Development Control
Ribble Valley Borough Council

Your ref: 24.0593
Our ref: D3.24.0593
Date: 5th September 2024

Address: 19 Abbey Road Whalley

Proposal: Proposed demolition of existing lean-to single-storey extension to rear and replacement with larger single-storey extension with a lantern roof. Conversion of double garage to single-storey annex accommodation with new pitched roof and installation of solar panels

SHEET:
EXISTING AND PROPOSED SITE
PLANS

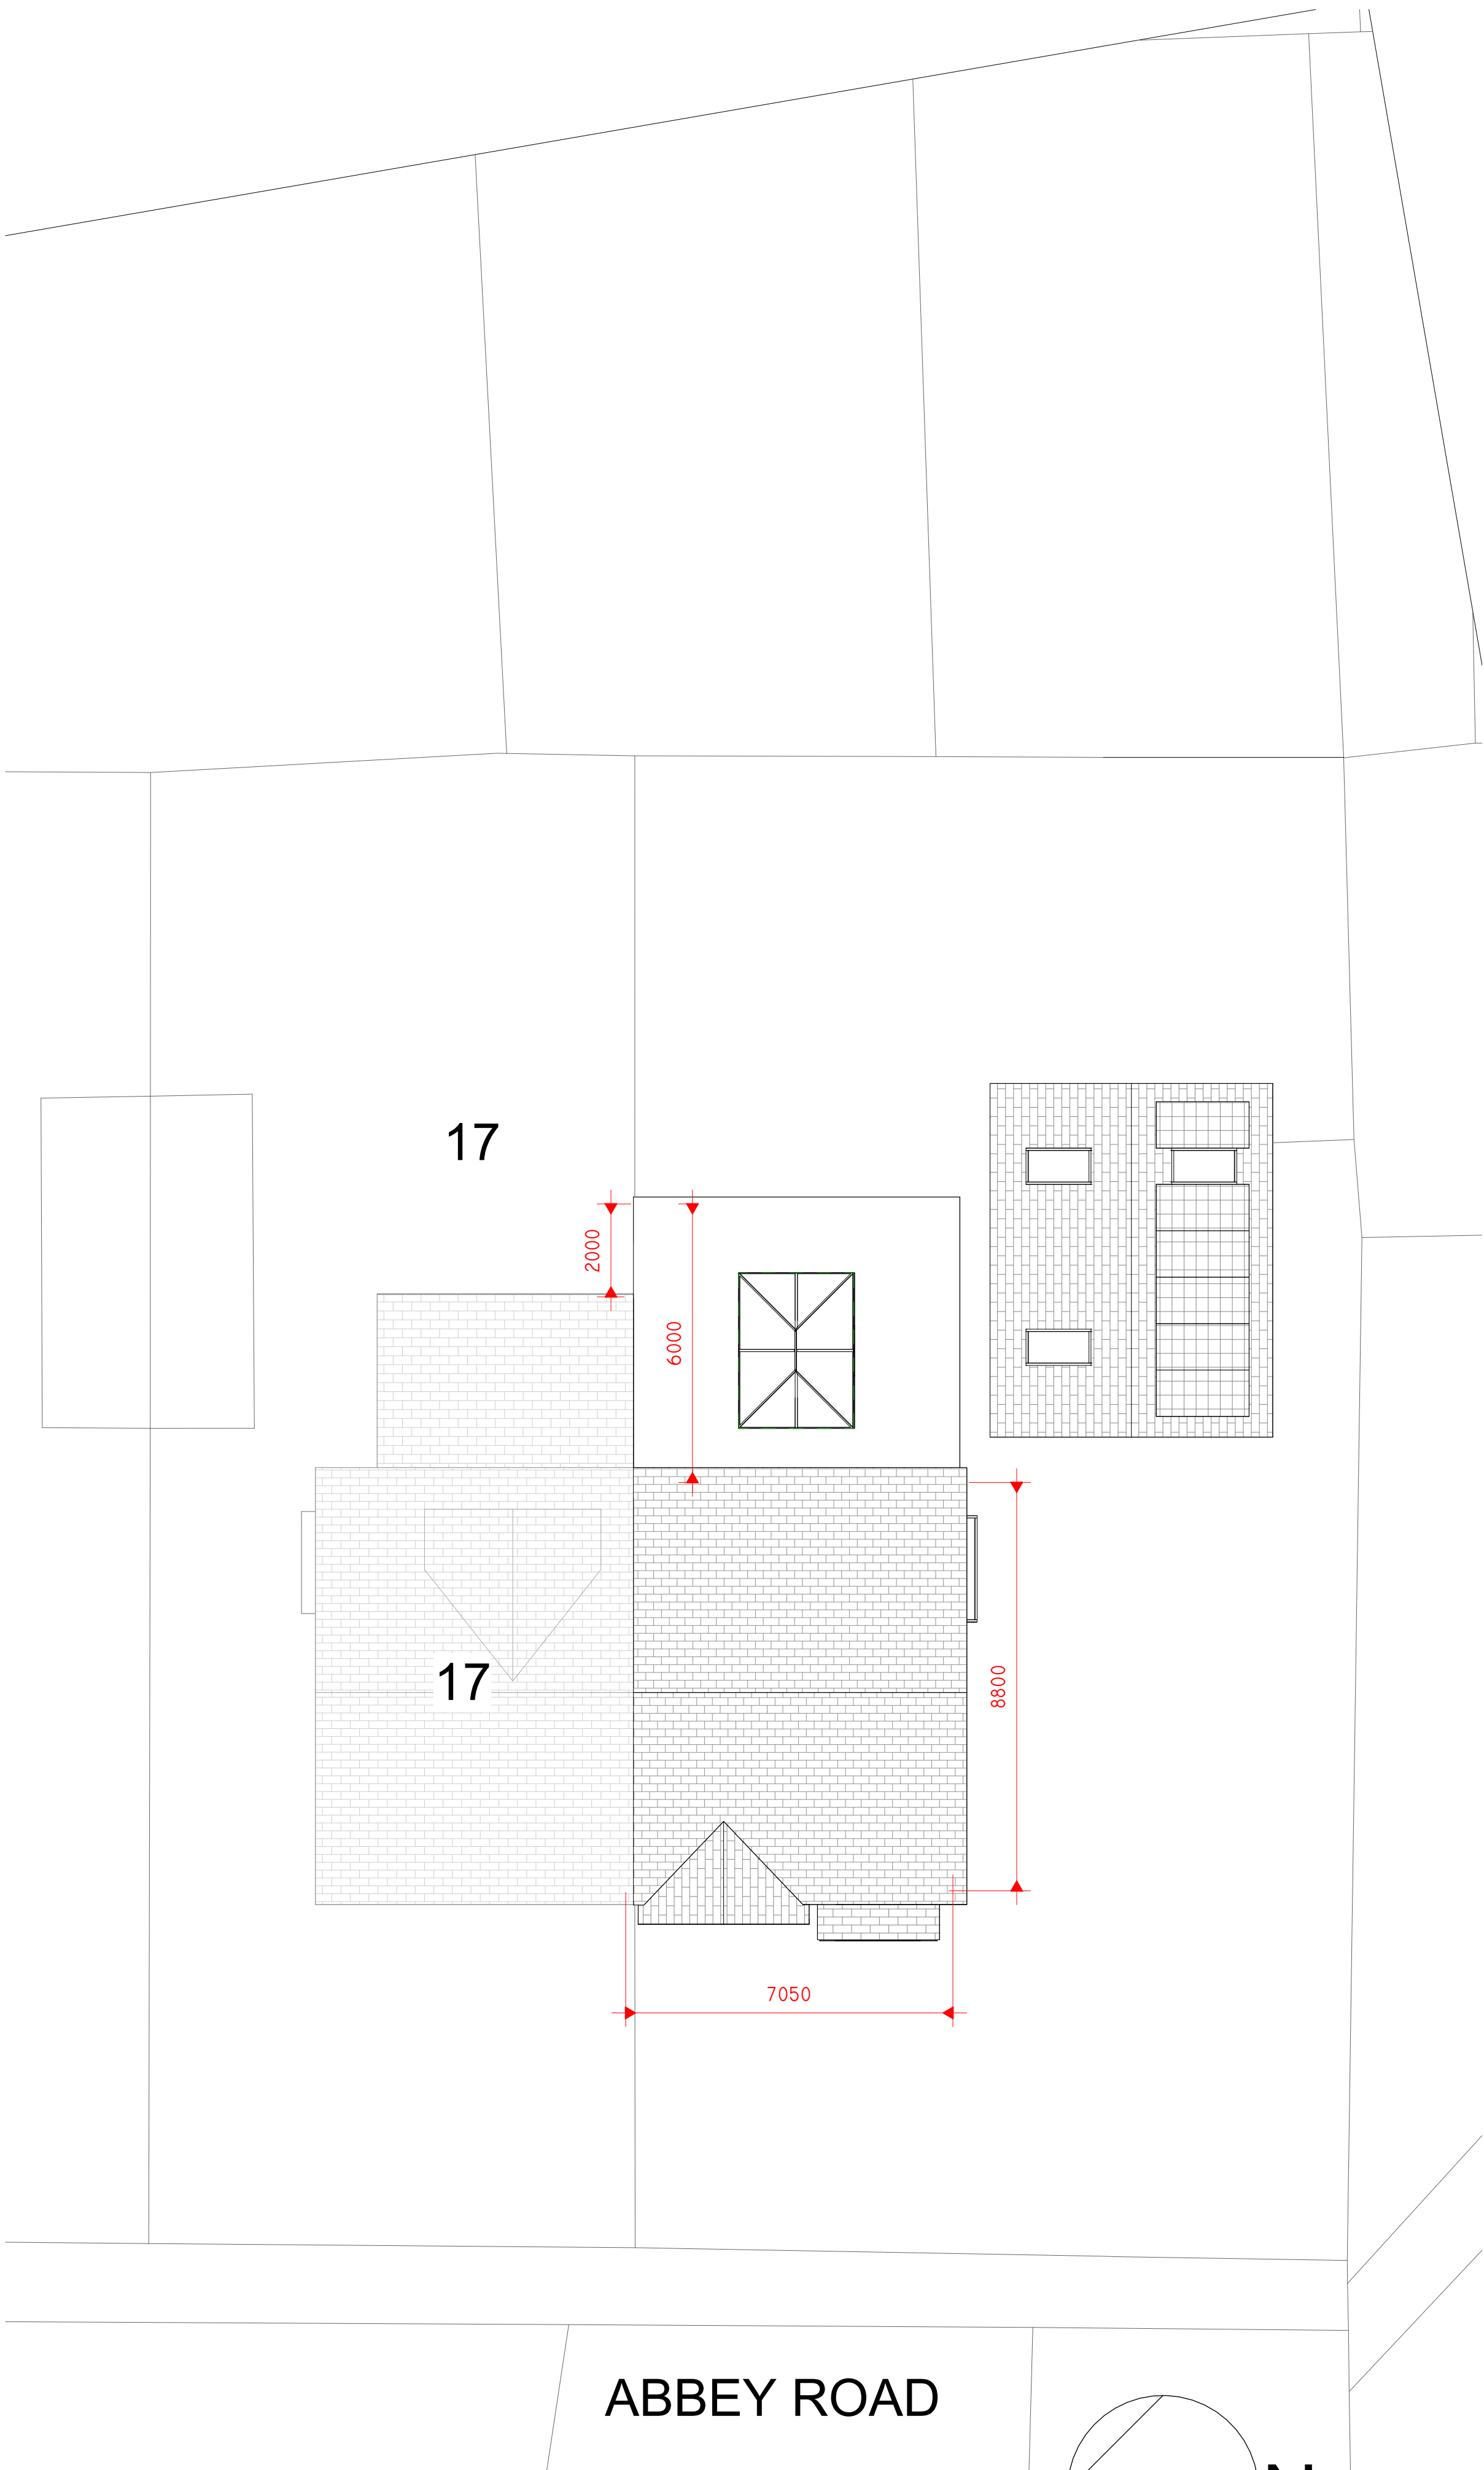
There is an existing access on Abbey Road which will continue to serve the dwelling and will serve the annex. No changes are proposed and none are considered necessary. The existing driveway provides parking for 4 vehicles which is considered necessary for this proposal.

We would request that a secure covered cycle store is provided due to the loss of the garage, to support sustainable travel.
